Recommendation Report for Planning Permission for Works or Extension to a Dwelling

REF NO: BR/117/22/HH

LOCATION: 82 Victoria Drive
Bognor Regis
PO21 2TA

PROPOSAL: Erection of part first floor extension over existing ground floor including part two storey element to rear with Juliette balcony to front elevation, widening of drop kerb and replacement boundary wall.

Drawing:
**Existing and Proposed
Site Plan**

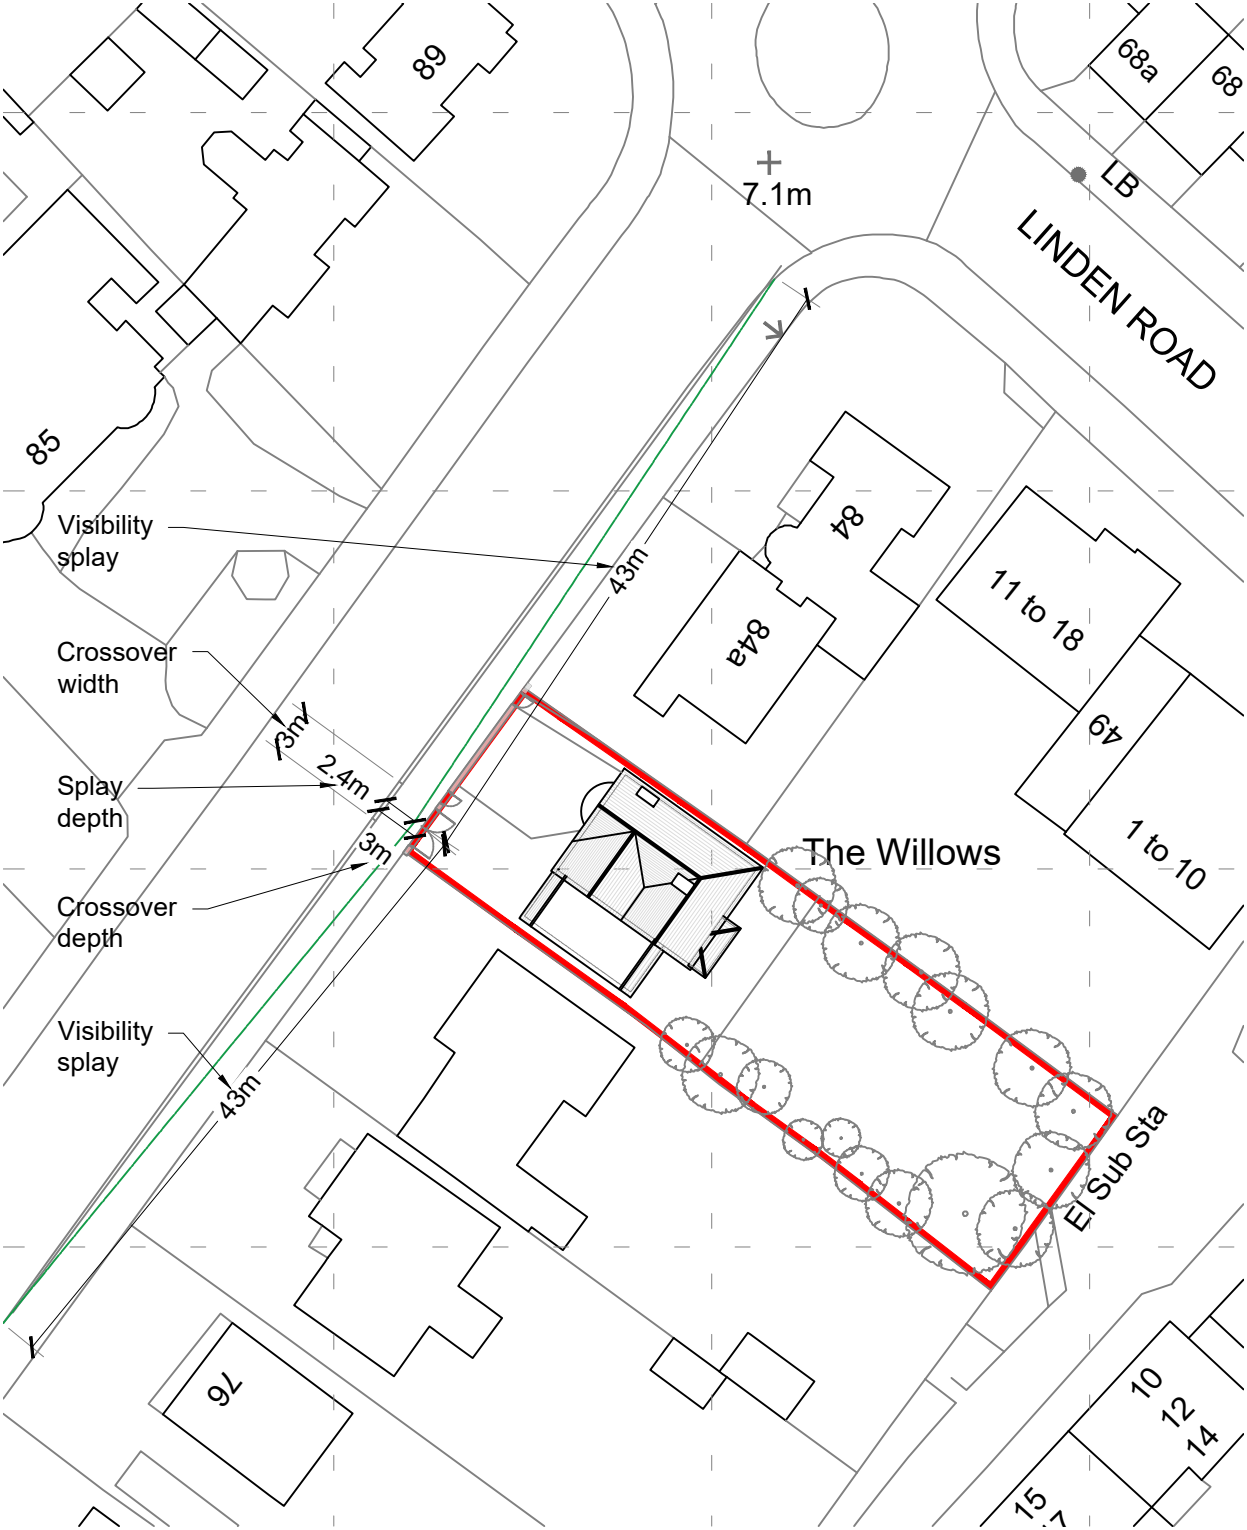
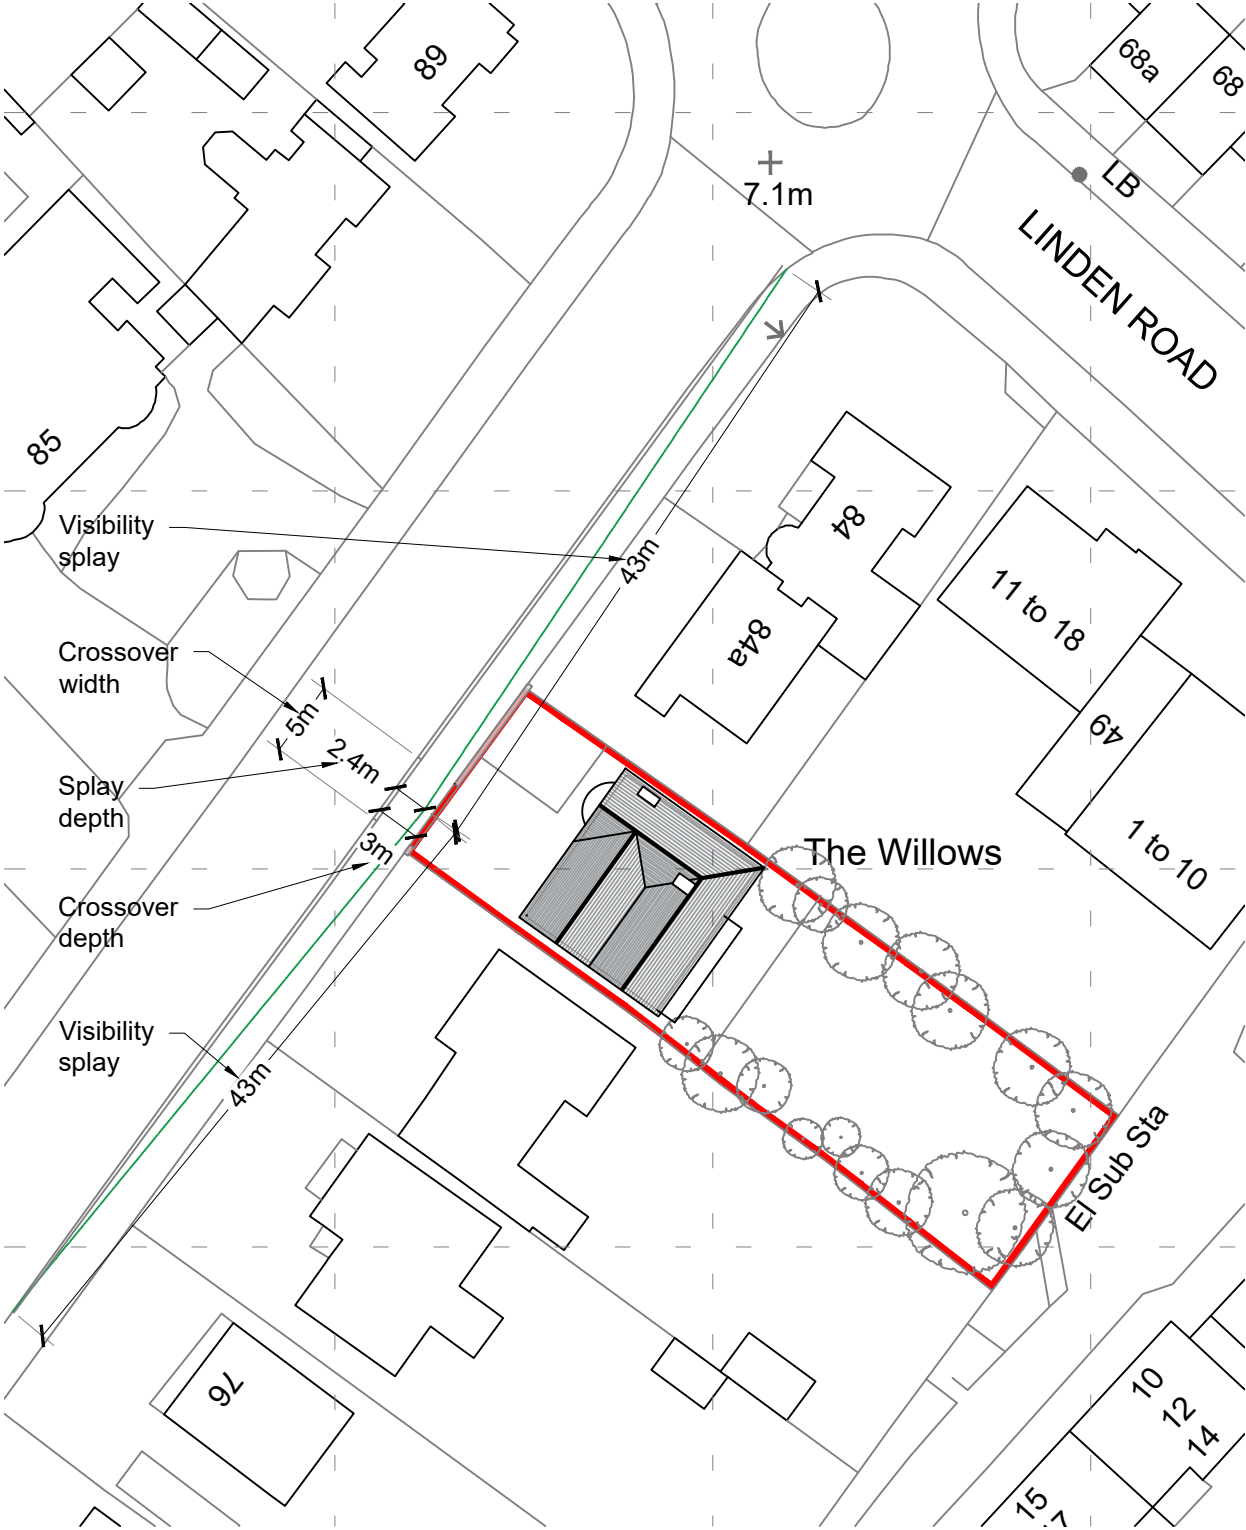
Along the front boundary, there will be a replacement boundary wall. This is slightly smaller in height than existing at 1m and is shortened in width enabling additional off-road parking to be constructed. The height and design of the boundary treatment is consistent with that within the street scene.

To the front an existing dropped kerb will be widened to 5m. This enables two cars to enter and exit the driveway more comfortably, providing better off road parking. The proposal will therefore not result in harm upon the highway in compliance with T SP1 of the Plan.
